Application for a non-material amendment following a grant of planning permission.

Number	
Suffix	
Property name	Brambles
Address line 1	Hurst Road
Address line 2	
Address line 3	
Town/city	East Preston
Postcode	BN16 3AP
Description of site location must be completed if postcode is not known:	
Easting (x)	506382
Northing (y)	102640

Construction of a single storey extension.

Reference number: R/210/20/HH

Existing Floor
Plan in Grey

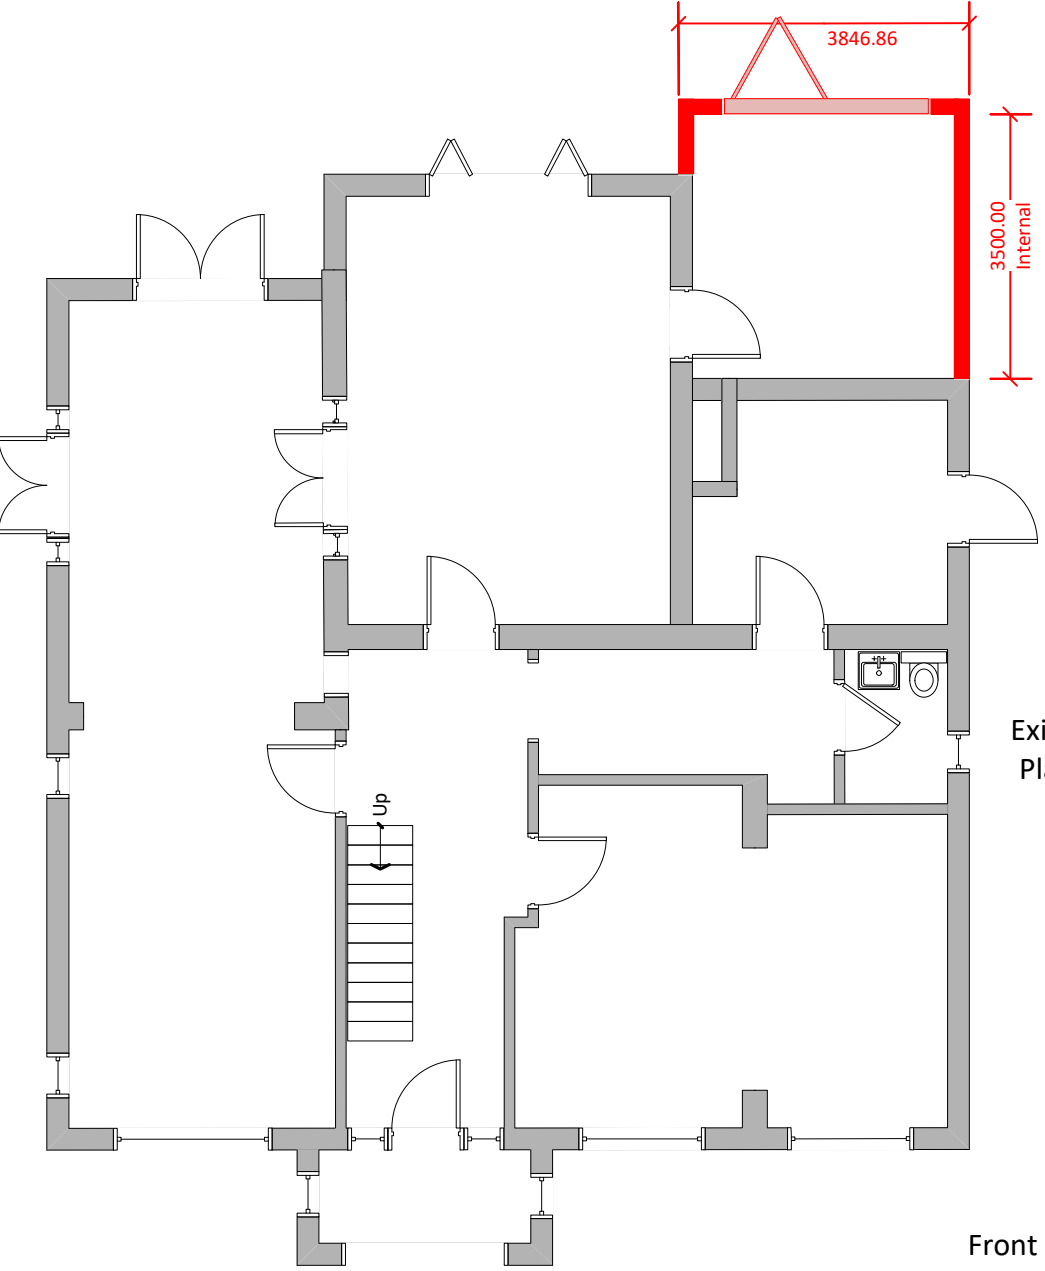
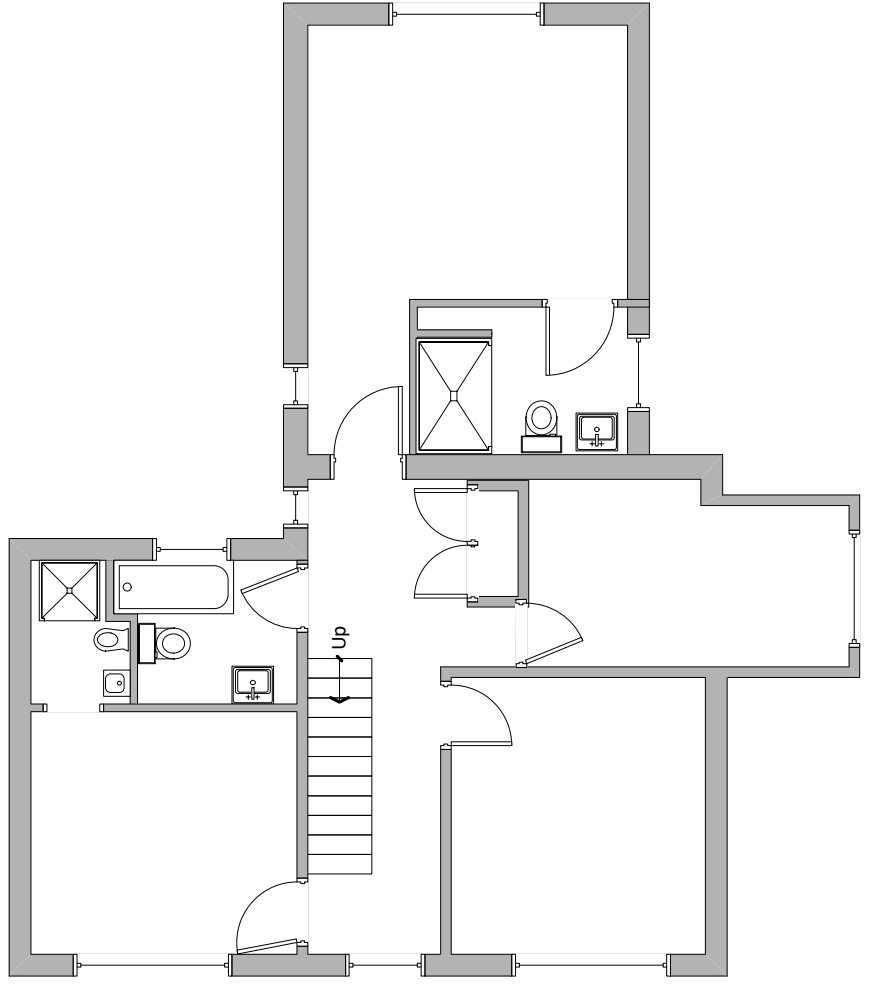
Addition of roof lights to the proposed extension and correction to the existing floor plan.
The existing floor plan does not match the proposed elevations drawing due to an administrative error and needs to be replaced so that all documentation is correct.
This situation has been discussed with Nicola Spencer who is aware of the situation.

The modification to the roof plan is to add roof lights to provide additional light into the two rooms. The proposed roof lights will be below the top of the roof surround and will not be visible from the side of the property. They do not affect the proposed elevations. The change to the floor plan is to bring the floor plan in line with the existing proposed elevations. Due to an administration error the latest version of the floor plan was not uploaded to the planning site before the decision was finalised.
